CITY OF ALBUQUERQUE

**RE: Albuquerque Central Care Center
621 Columbia Dr. SE
Grading and Drainage Plan
Engineer's Stamp Date: 10/09/19
Hydrology File: L16D042**

Based upon the information provided in your submittal received 11/13/2019, the Grading & Drainage Plan **is not** approved for Building Permit. The following comments need to be addressed for approval of the above referenced project:

**C-2**

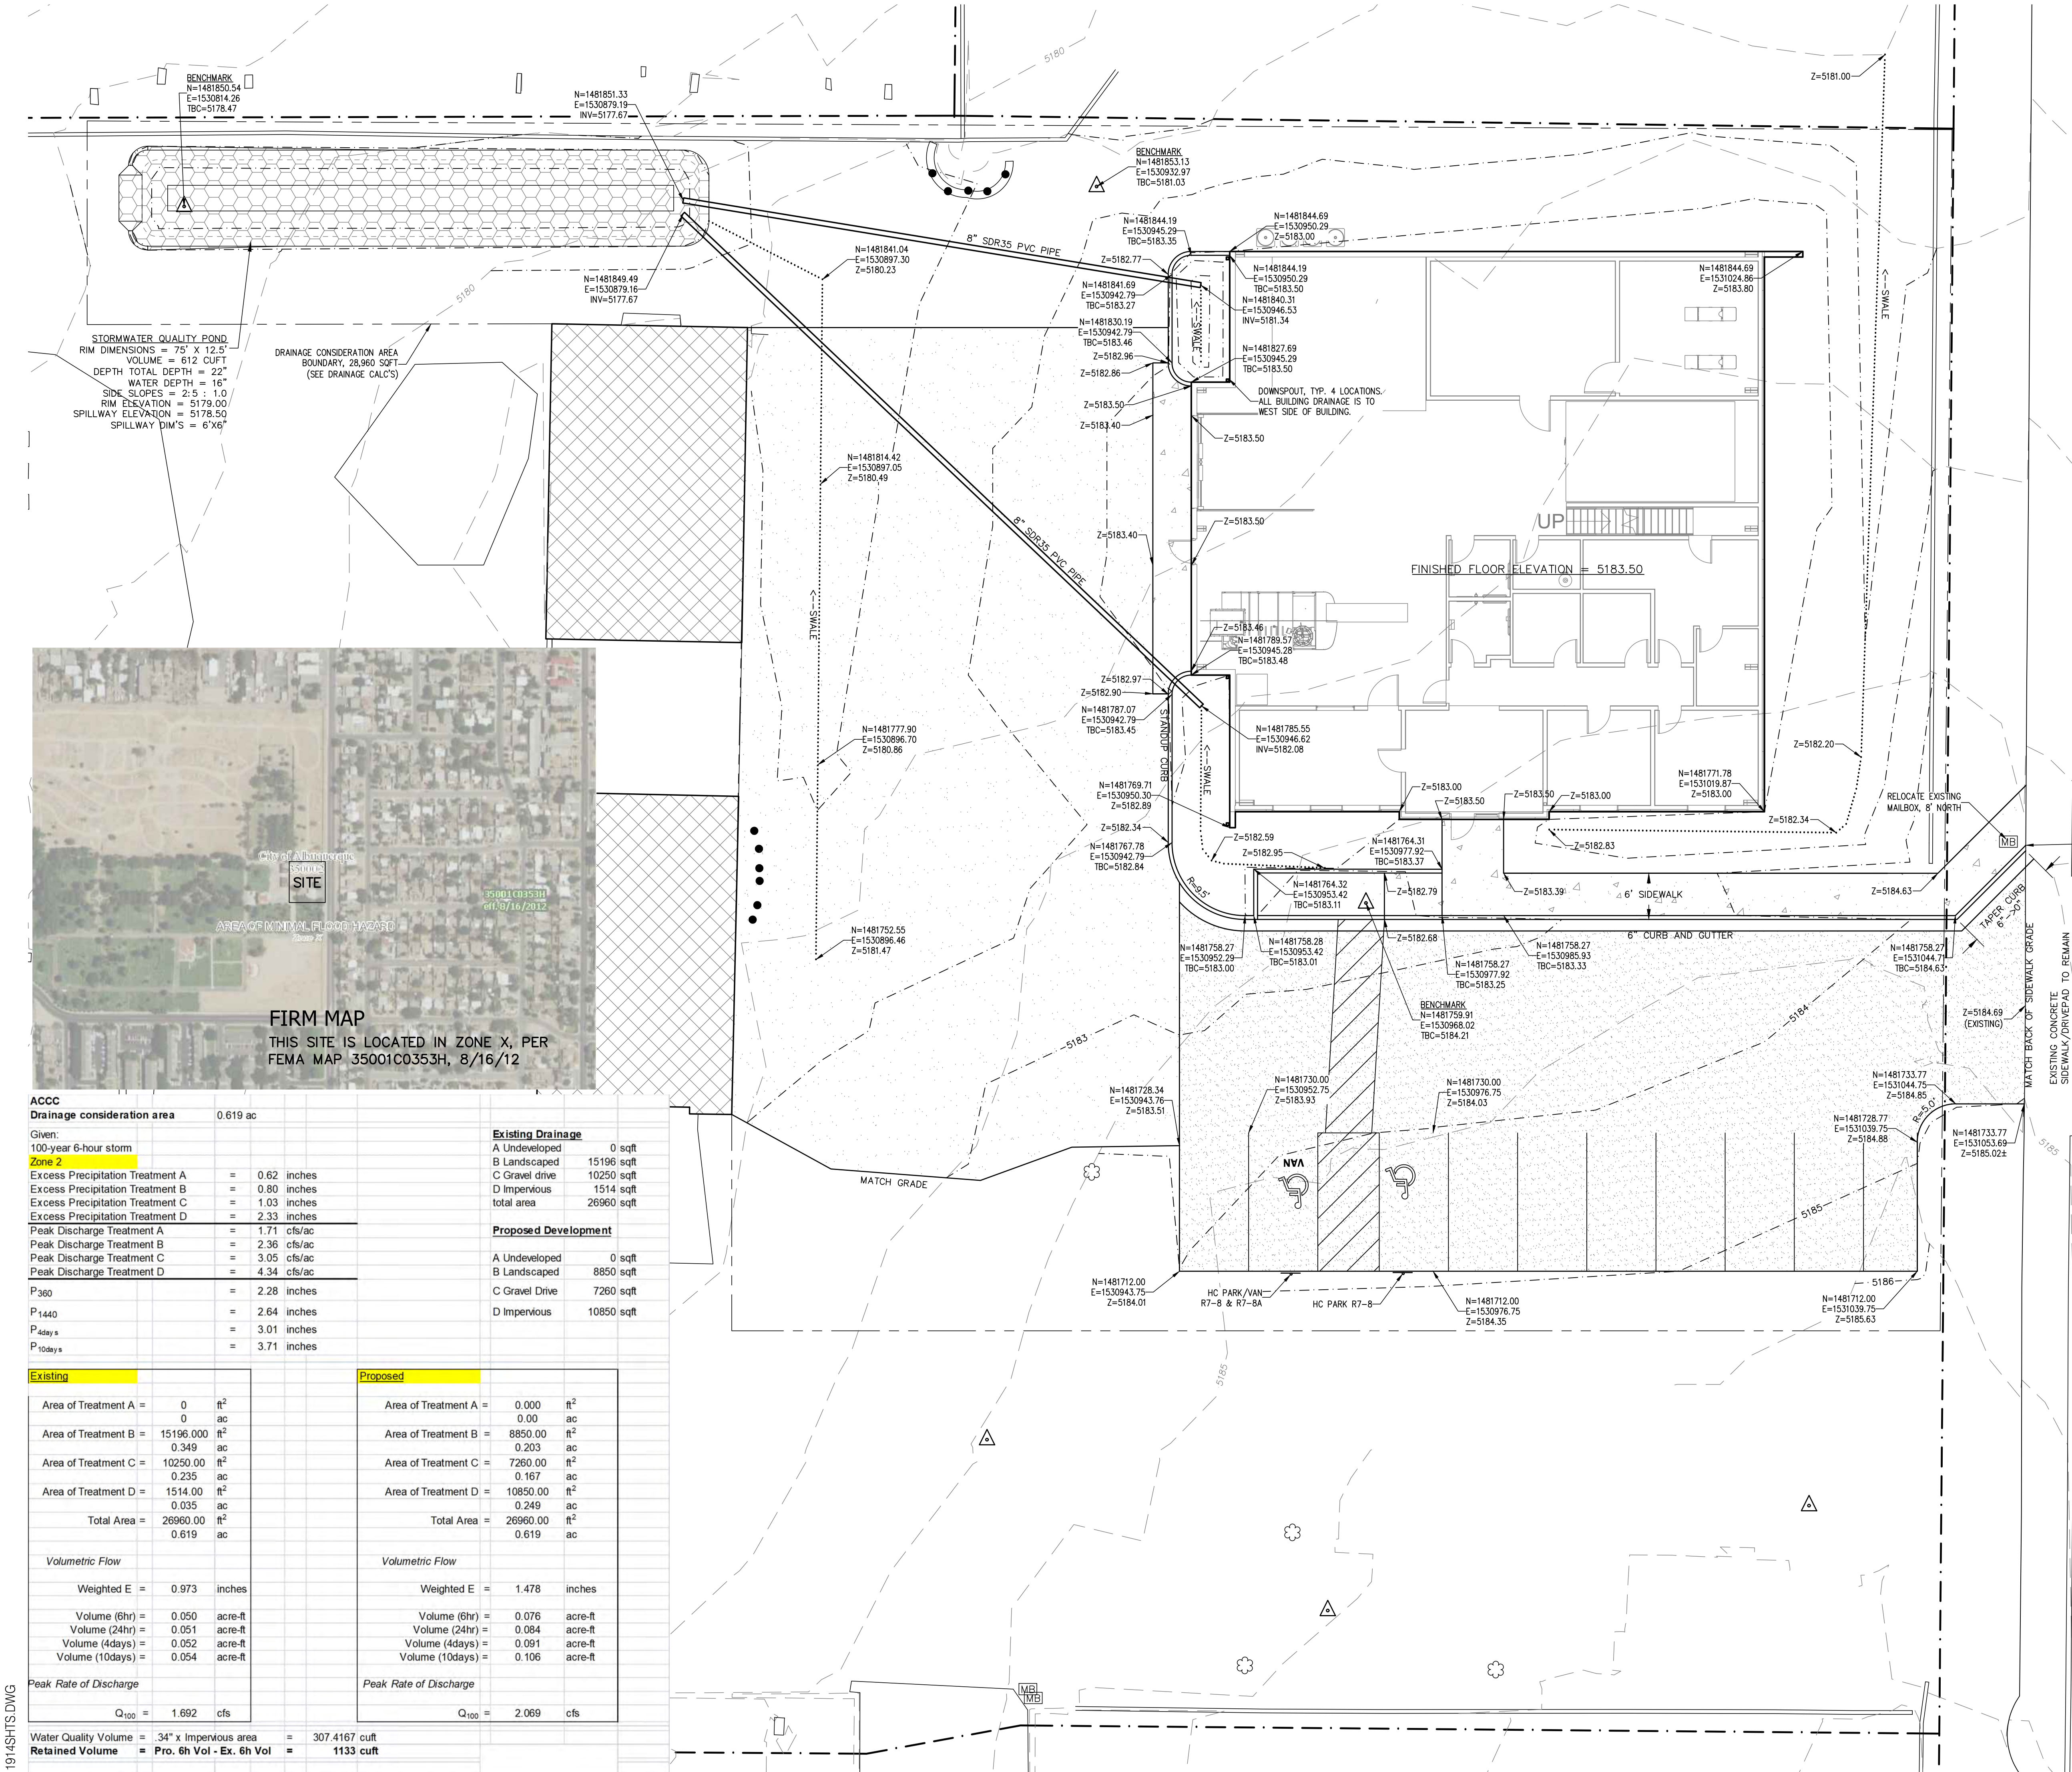
1. Per the DPM Chapter 22 Section 7 - Grading Plan Checklist, the following must be on the Grading Plan. Please correct any deficiencies with the Grading Plan.

- a. Please provide an engineer's stamp with a signature and date.
 - b. Please use 1" = 20' for the scale.
 - c. Please provide a Vicinity Map.
 - d. Please provide the Benchmark information (location, description and elevation) for the survey contour information provided.

- e. Please provide the FIRM Map and flood plain note with effective date.
 - f. Please provide a legal Description of the property.
2. Please provide the required water block per COA Paving Detail No. 2426 at the driveway. This is to ensure that the drainage from Columbia Dr. does not enter the site.

3. Is this property to be platted? If so, then please show the preliminary property line. Also when you resubmit, please also ask for an approval for Preliminary Plat.

4. In the drainage calculations, please use the proposed acreage of the Preliminary Plat as the total area in all the calculations. Also for the Existing Drainage calculations, there will be no Type A (native soil) in this area. This site is comprised of either

landscape area (Type B), graded earth or gravel (Type C), and impervious (Type D). Please correct the calculations.

5. Please change the pond from “Retention Pond” to “Stormwater Quality Pond”. This is the terminology that was changed in the latest Drainage Ordinance.
6. Standard review fee of \$150 will be required at the time of resubmittal.
